The Examining Authority presented a series of questions which were outlined in its letter of 14 January 2025 to the Applicant and other Interested Parties, in order to receive further information about matters it considered relevant to the application. Newark and Sherwood District Council has responded to these questions in the following report and has provided the following schedule which provides an easy reference guide for the Examining Authority to see the comment to each of the questions posed to us.

1. General overarching matters including Policy, Need and Alternatives		
EXQ2 Question Number	Question	NSDC Response
Q1.0.1	<p>National Planning Policy Framework</p> <p>A revised National Planning Policy Framework (the Framework) was published on 12 December 2024. All Parties confirm whether there are any changes to your case resultant from changes to the Framework and if so, set out the amended policy and how this changes your case. Furthermore whether you consider this changes the scope of any of the Applicant's Assessments or the basis for the Secretary of State's conclusions.</p>	<p>The revised NPPF has resulted in an increase to the housing requirement for Newark and Sherwoo

**Viewpoint 24: View north from Sandhills Park representative of views for residents.**

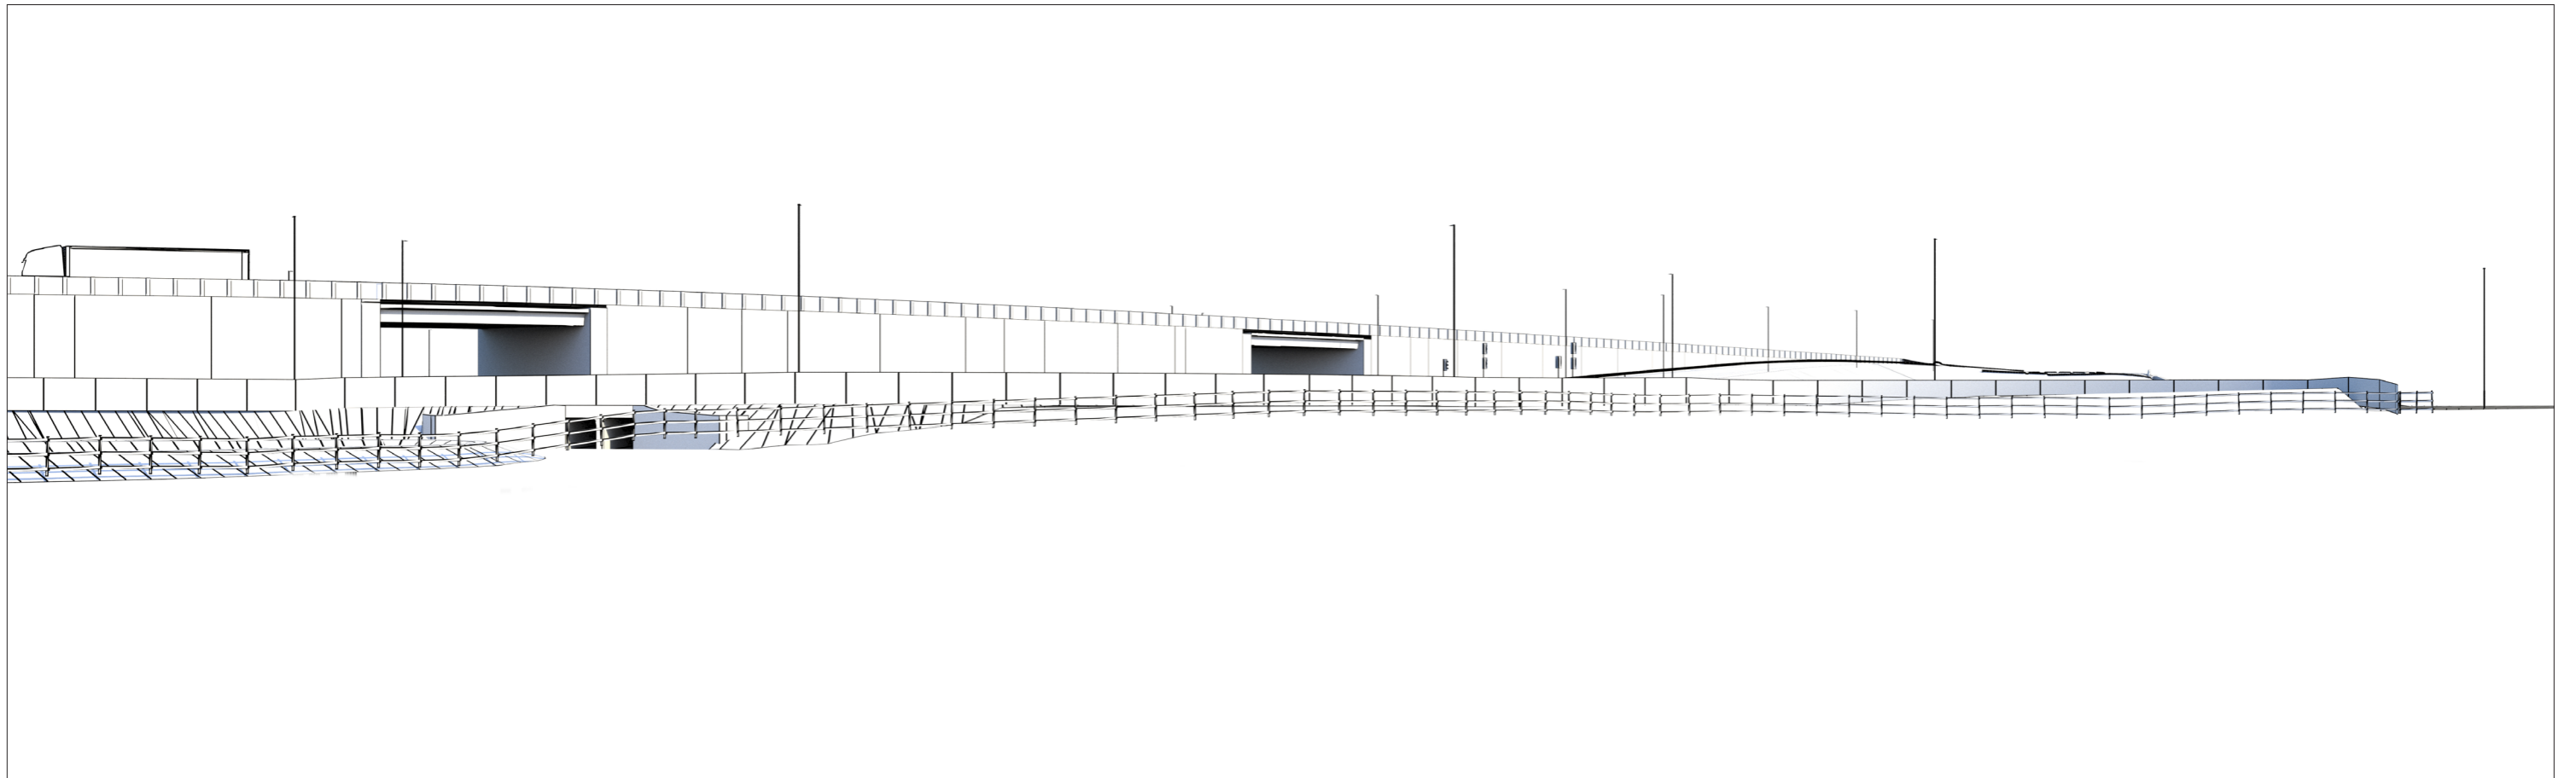
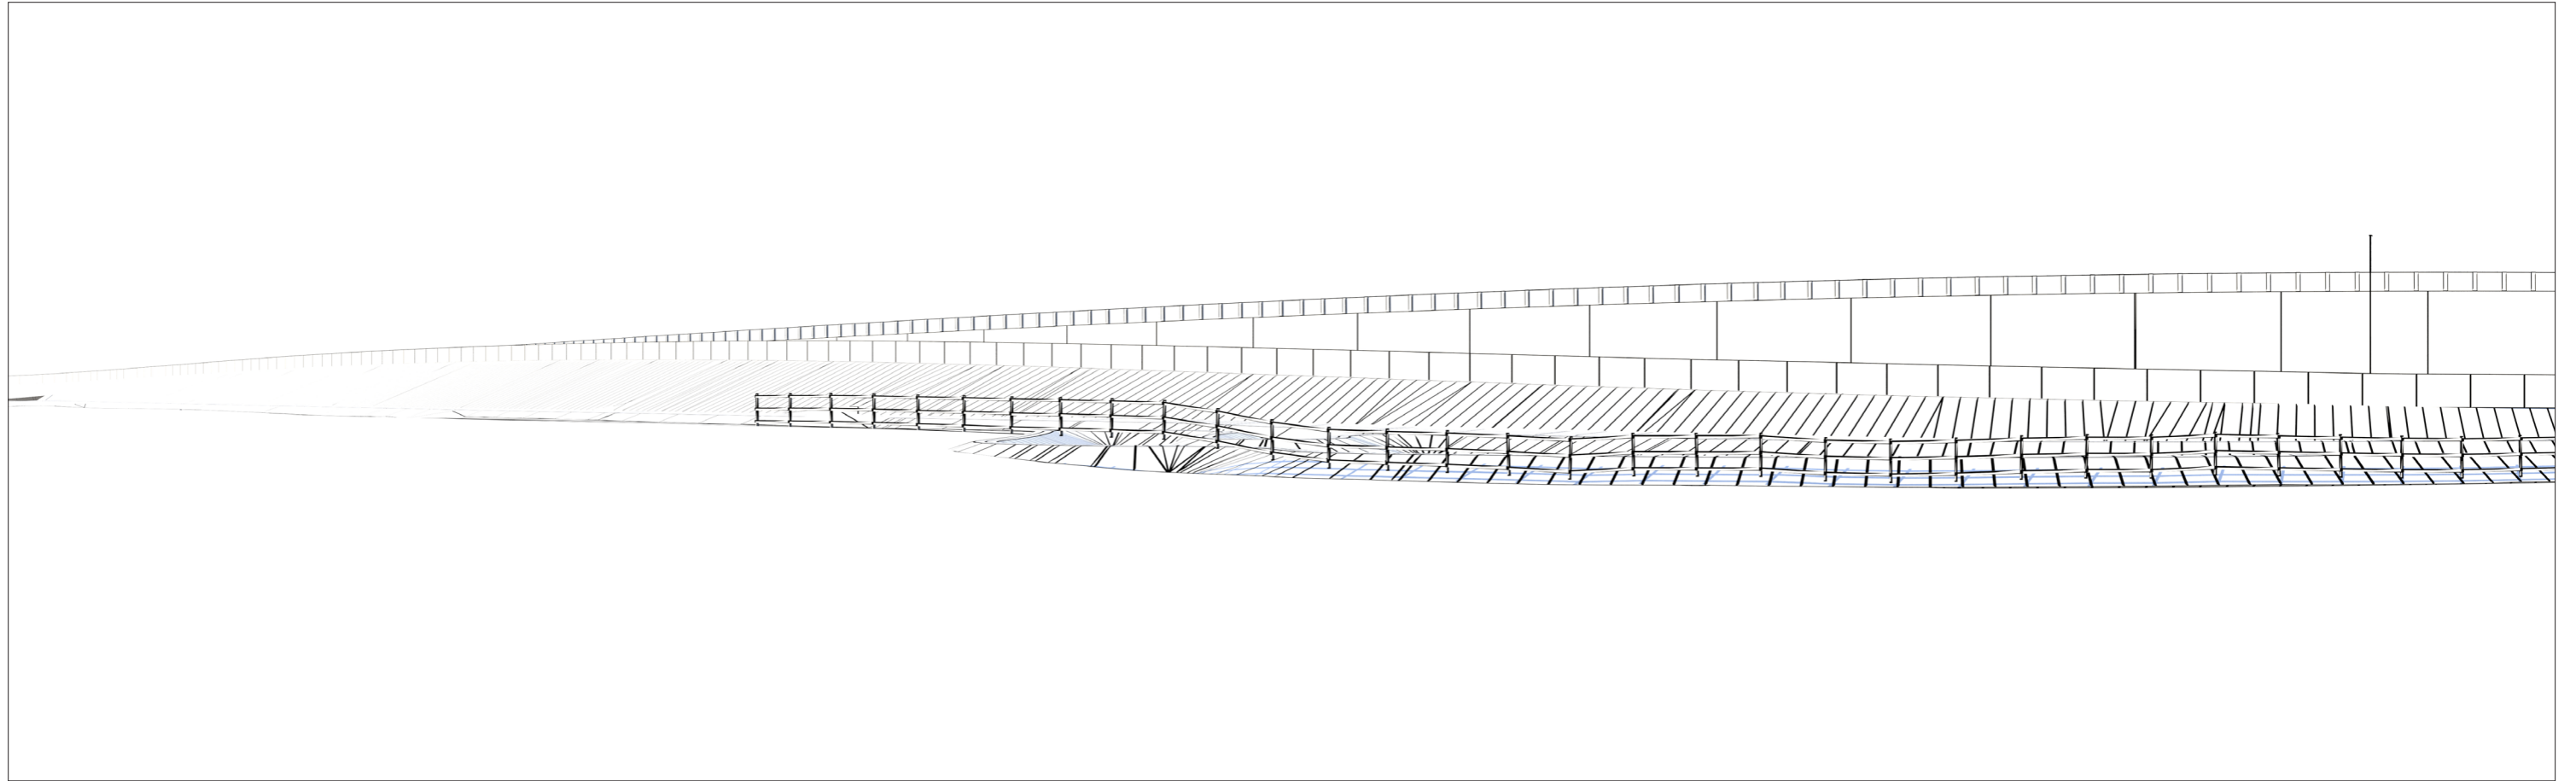
include some of the recommendations of SEO2 that would both enhance this approach and substantially improve the screening, reduce the overall impact of this structure.
Q10.0.3	<p>Impact on Residential Properties at Sandhills</p> <p>Following receipt of [REP4-039], please provide an updated comment in relation to the effects on those residents at Sandhills and please provide any suggested mitigation measures that may reasonably be capable of being implemented.</p>	<p>The impact on residential properties at Sandhills is illustrated by Viewpoint 24 (7.57 Additional Visual Effects Information) with an additional wireframe having been produced by the applicant that depicts the view without any existing intervening built form or vegetation.</p> <p>Existing built form comprises a flood bund that sits to the rear of property boundaries in Sandhills and is outside the site boundary. Existing vegetation (occasional small trees, and scrub) is within the field to the north of Sandhills southwest of the A46 roundabout junction as well as on the roundabout itself.</p> <p>The proposed linear belts of tree planting to the southwest of the Proposed A46 Cattle Market junction (shown on Figure 2.3 Environmental Master plan sheet 3 of 7) will partially break up the mass of the elevated retaining wall by Year 15. Closer to the Cattle Market junction structure where there are existing drainage constraints and proposed waterbodies, tree planting is very limited with intermittent tree planting on the roundabout and lines of individual trees on the edge of northern bank of the proposed waterbody and on the perimeter of the temporary construction compound only.</p>

<p>Suggested mitigation to reduce the impact to Sandhills (Viewpoint 24) are:</p> <p>1) Reconfiguring the shape of the proposed water body directly north of Sandhills (pulling it further south to allow a line of trees to be planted to the western toe of the existing flood bund at the closest point to the receptors of Sandhill.</p> <p>2) The applicant should explore all opportunities to increase tree cover within the open grassed area southeast of the roundabout junction and closest to VP 24. While it is understood there are existing drainage constraints within this area, we feel there is opportunity for further tree planting here as screening of the considerable visual impact created by the structure. Planting should be considered as near to the culvert as can be permitted to close down the angle of view. While this will not screen all the view it should reduce the extent of the impact considerably. The applicant should evidence all constraints that prevent the increase in tree planting here.</p>

# Additional Wireframe from Great North Road looking north towards Cattle Market Junction

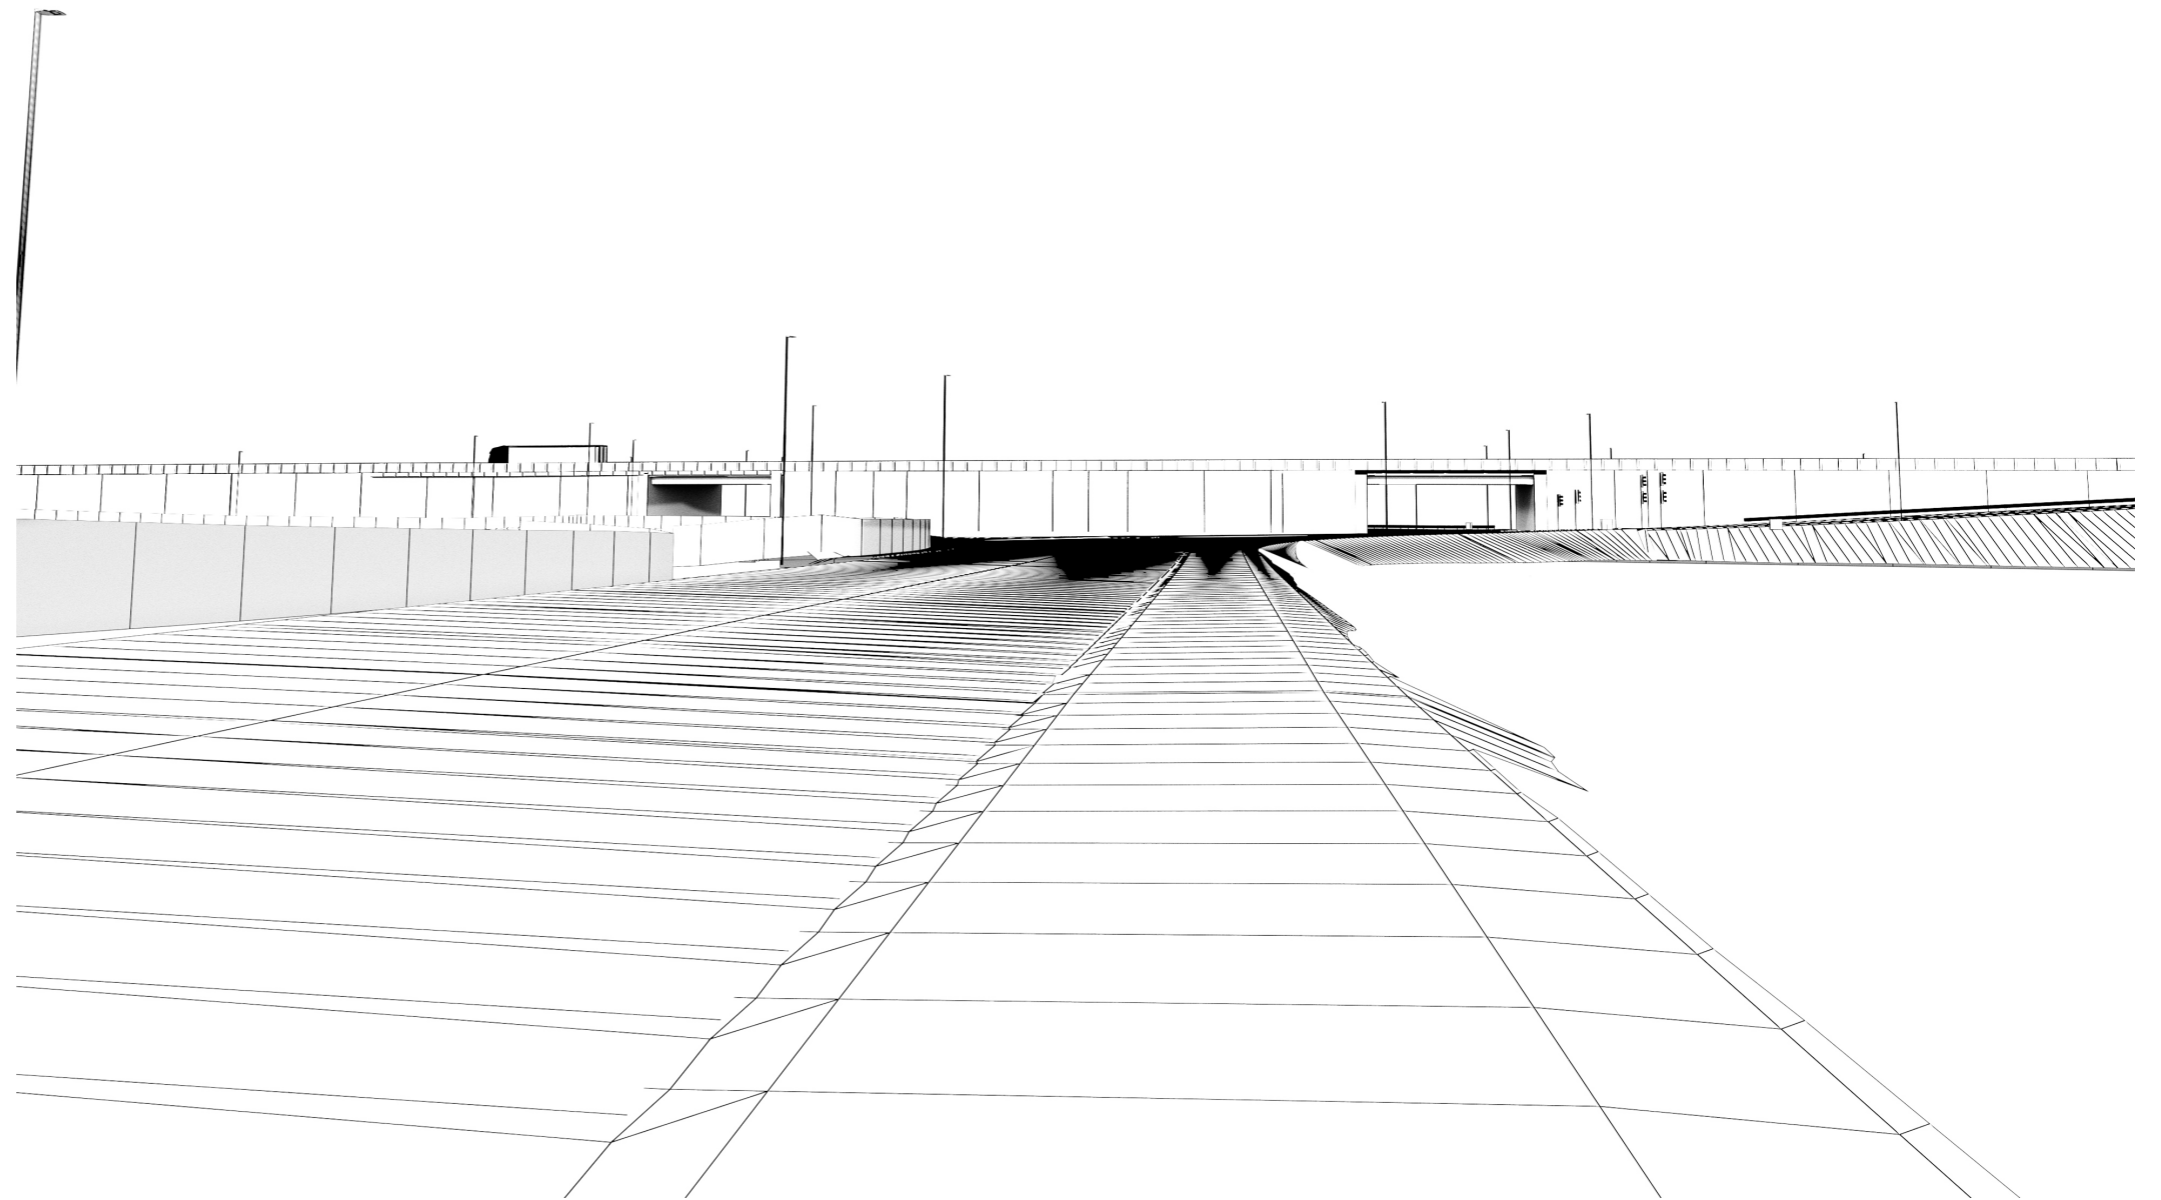
<p>Please expand on your submission [REP4-048] with respect to the Applicant's landscaping around the Cattle Market junction and its consistency, or otherwise, with the features highlighted in National Character Area (NCA) 46.</p>	<p>relevant to the Cattle Market Junction are shown in bold text and include:</p> <ul style="list-style-type: none"> ▣ A gently undulating and low-lying landform in the main, with low ridges dividing shallow, broad river valleys, vales and flood plains. The mature, powerful River Trent flows north through the full length of the area, meandering across its broad flood plain and continuing to influence the physical and human geography of the area as it has done for thousands of years. ▣ Agriculture is the dominant land use, with most farmland being used for growing cereals, oilseeds and other arable crops. While much pasture has been converted to arable use over the years, grazing is still significant in places, such as along the Trent and around settlements. ▣ A regular pattern of medium to large fields enclosed by hawthorn hedgerows, and ditches in low-lying areas, dominates the landscape. ▣ Very little semi-natural habitat remains across the area; however, areas of flood plain grazing marsh are still found in places along the Trent. Notably the Headline Statement of Environmental Opportunity (SEO) have four specific actions for this National Character two of which relate to vegetation cover and the character of the Trent Vale. These are:

<p>SEO 2</p> <p>☐ Enhance the woodland and hedgerow network through the planting of small woodlands, tree belts, hedgerow trees and new hedgerows to benefit landscape character, habitat connectivity and a range of ecosystem services, including the regulation of soil erosion, water quality and flow.</p> <p>SEO 4</p> <p>☐ Maintain and enhance the character of this gently undulating, rural landscape. Promote and carefully manage the many distinctive elements that contribute to the overarching sense of place and history of the Trent and Belvoir Vales.</p> <p>These are relevant to the approach from the north to the Cattle Market junction and the proximity to the river with its flood plain pasture, linear tree belts and hedgerows and approach to the historic core of Newark.</p> <p>In answer to the question, ‘is the Applicant’s landscaping around the Cattle Market junction consistent with the features highlighted in National Character Area’, we would have to conclude it is not, when taking into consideration the recommendations of SEO2.</p> <p>The applicants' visualisations for viewpoint 25 at year 15 show a vast expanse of open grassland either side of the great north road approach to the junction. This area could</p>
